Subject: FW: App Ref: FP/248/20/PL - Land to North of Felpham, PO22 8FA - Sport England Ref: PA/21/SE/AR/57618

Subject: App Ref: FP/248/20/PL - Land to North of Felpham, PO22 8FA - Sport England Ref: PA/21/SE/AR/57618

Thank you for consulting Sport England in respect of the revised details relating to the sports pitch and changing facilities at this site.

Drawing Title:
CHANGING FACILITIES BUILDING

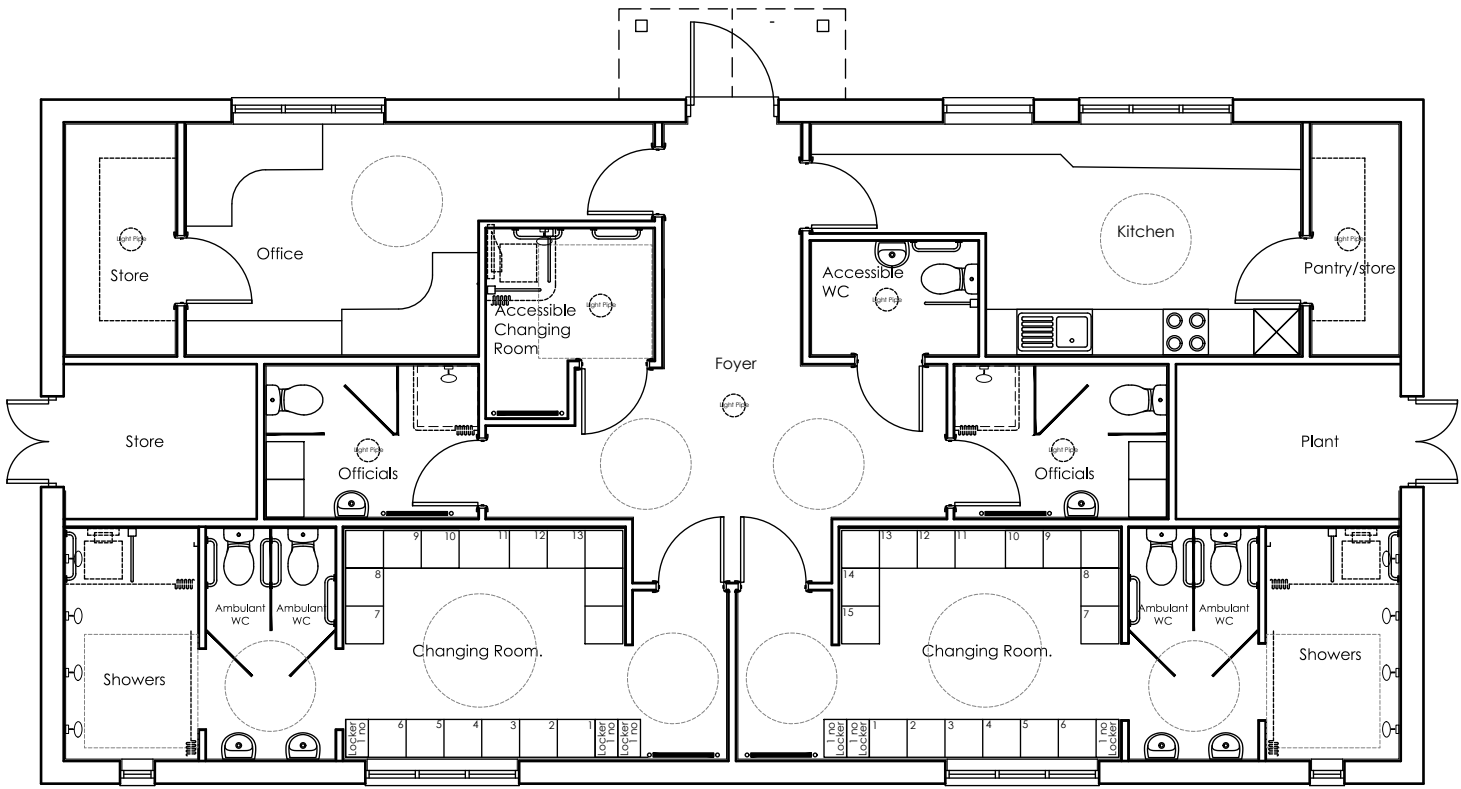
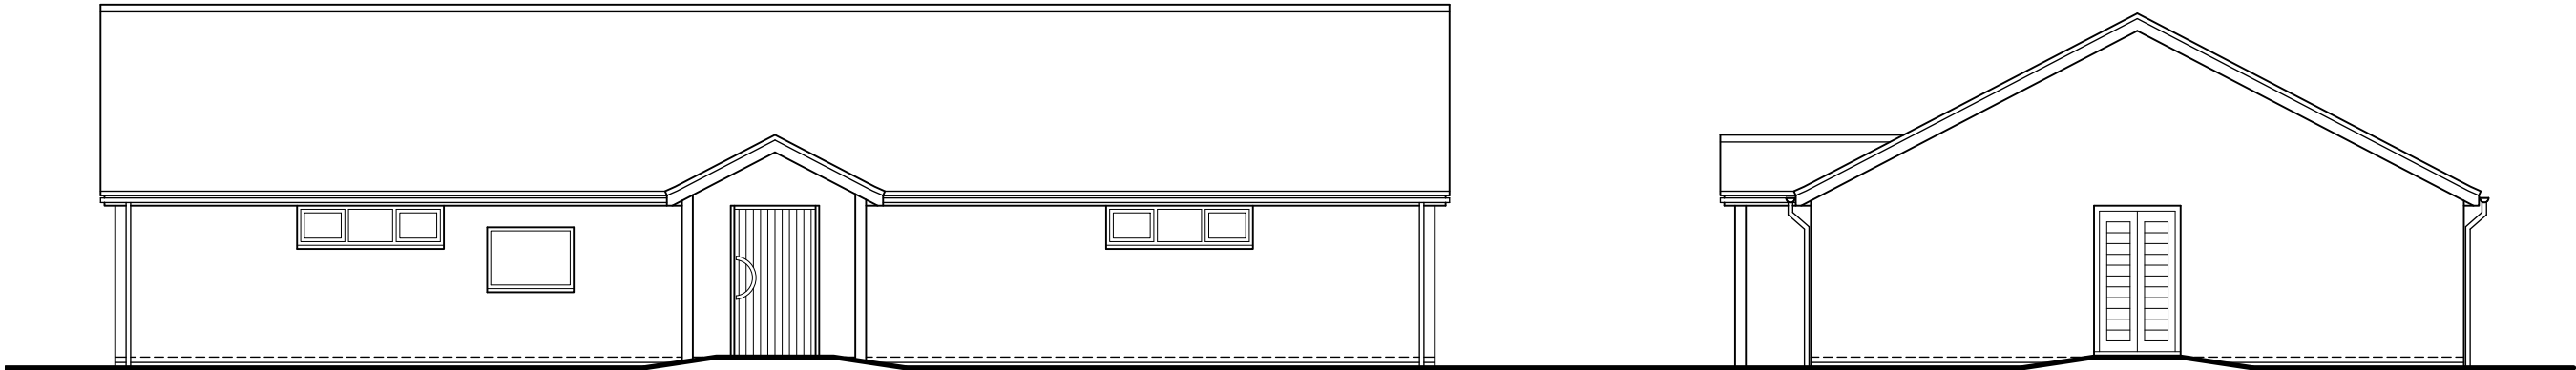
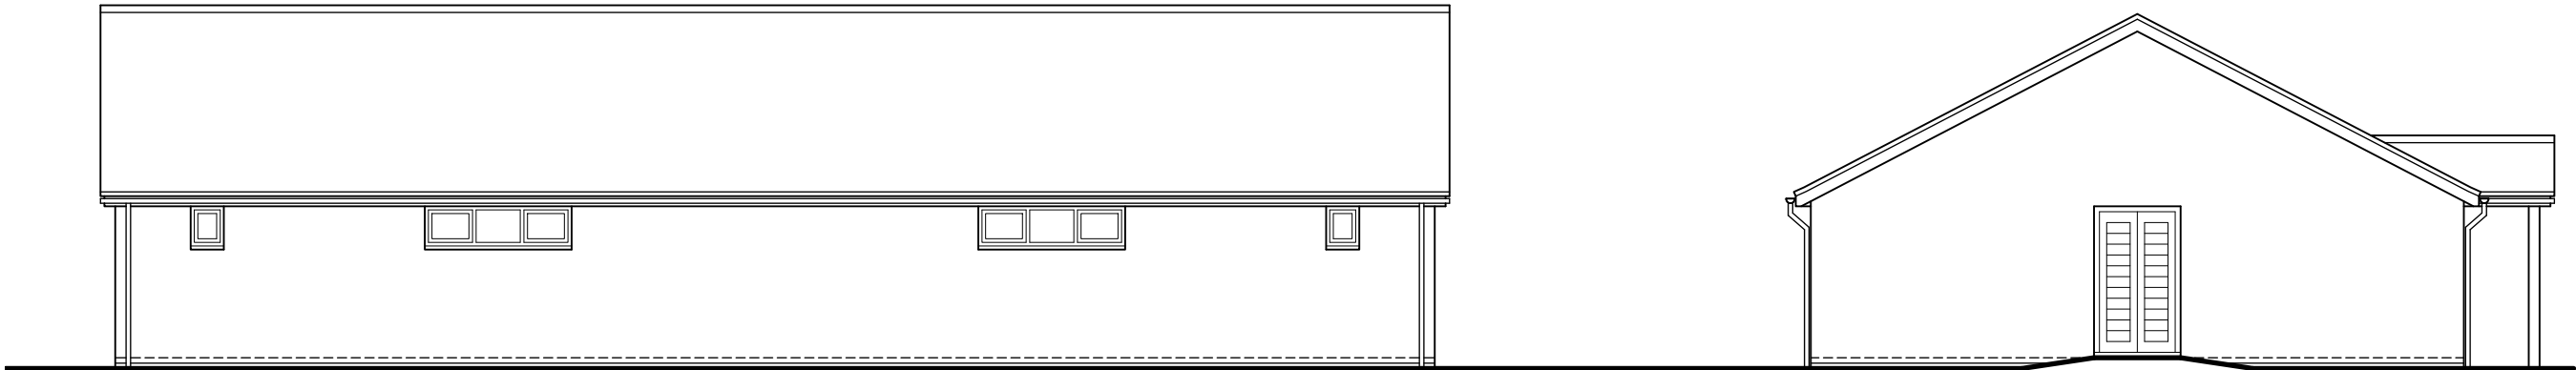
The changing rooms are not ideal. There is a clear line of sight from the lobby area into each changing room. There's only 1 officials changing room.

Looking at the site plan, there's only 1 pitch, so why are 4 team changing rooms proposed, only 2 are needed. The kitchen would also be better located on the edge of the building and use of external hatch to serve refreshments.
